WEST SUSSEX COUNTY COUNCIL CONSULTATION

TO:	Arun District Council FAO: Katie Sharp
FROM:	WSCC - Highways Authority
DATE:	4 May 2022
LOCATION:	Land at Arundel Road Angmering BN16 4ET
SUBJECT:	A/60/22/DOC Approval of details reserved by condition imposed under A/207/21/PL relating to conditions 8-Construction Management Plan, 20-location and installation of fire hydrants and 38-risk associated with contamination.
DATE OF SITE VISIT:	n/a
RECOMMENDATION:	More Information / Modification
S106 CONTRIBUTION TOTAL:	n/a

EXTRACT OF SITE PLANNING LAYOUT – PROVIDED AS REFERENCE ONLY

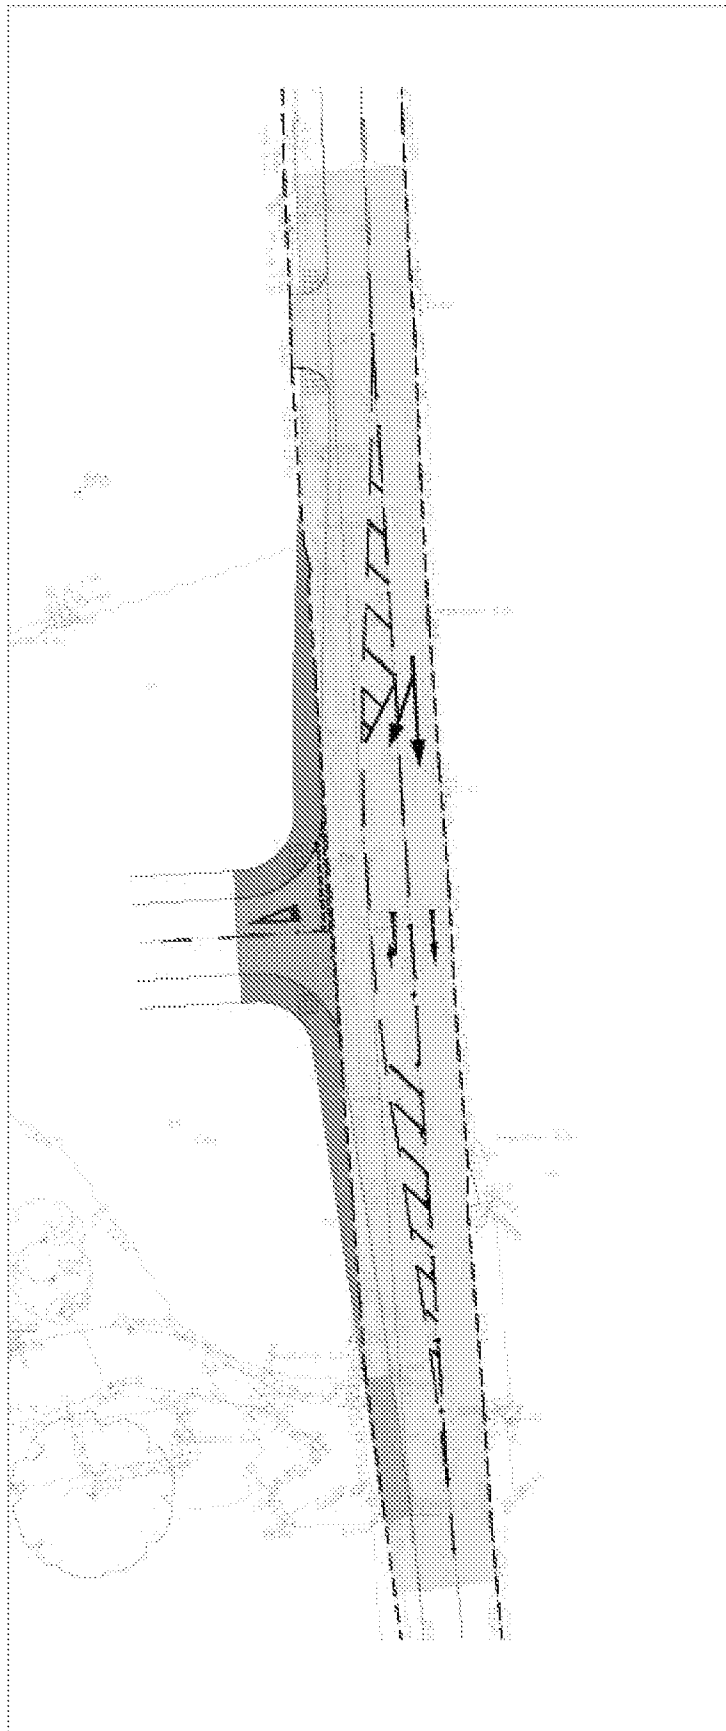
Ped/Cycle access and Phasing

As per comments on the RM application for the site, concerns are raised about the ability of pedestrians and cyclists to utilise the southern access. The phasing plan provided shows the properties in the south east corner appear to be very late in the development. which would support the development embedding sustainable trips from an early stage for the majority of residents

EXTRACT OF S278 DRAWINGS SHOWING TEMPORARY SITE ACCESS – PROVIDED AS REFERENCE ONLY

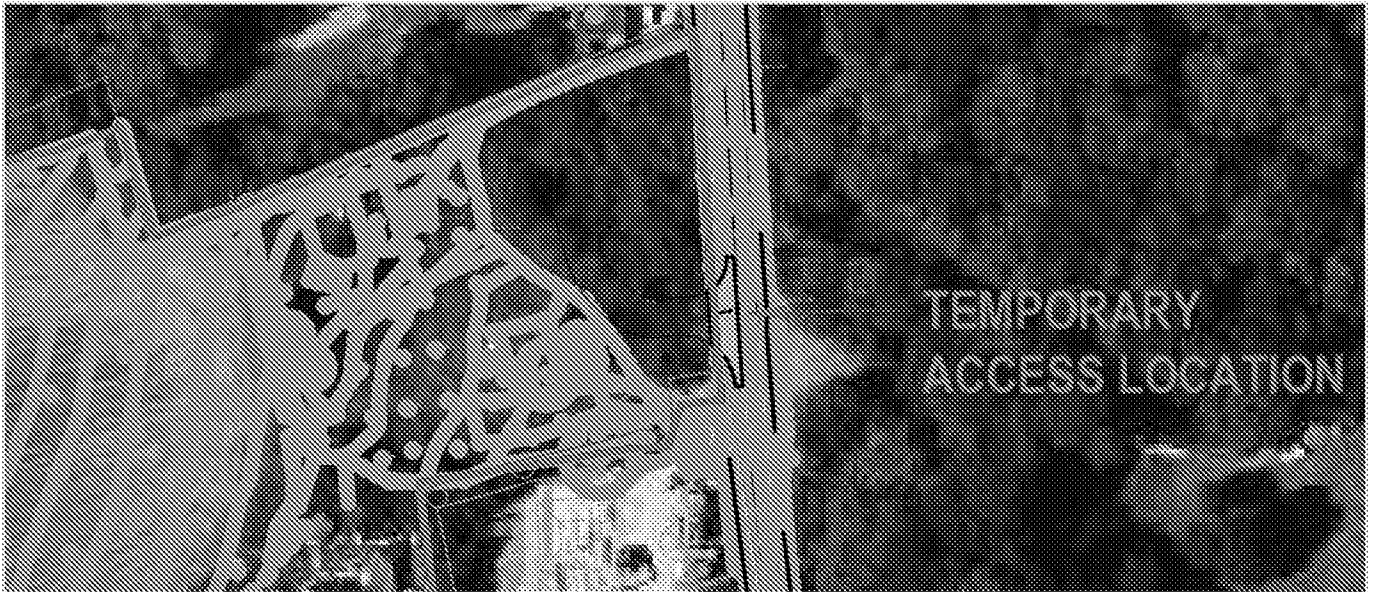
Temporary site access

Details of the visibility splays along the vertical plan should be provided to assess the suitability of the tempoary access.
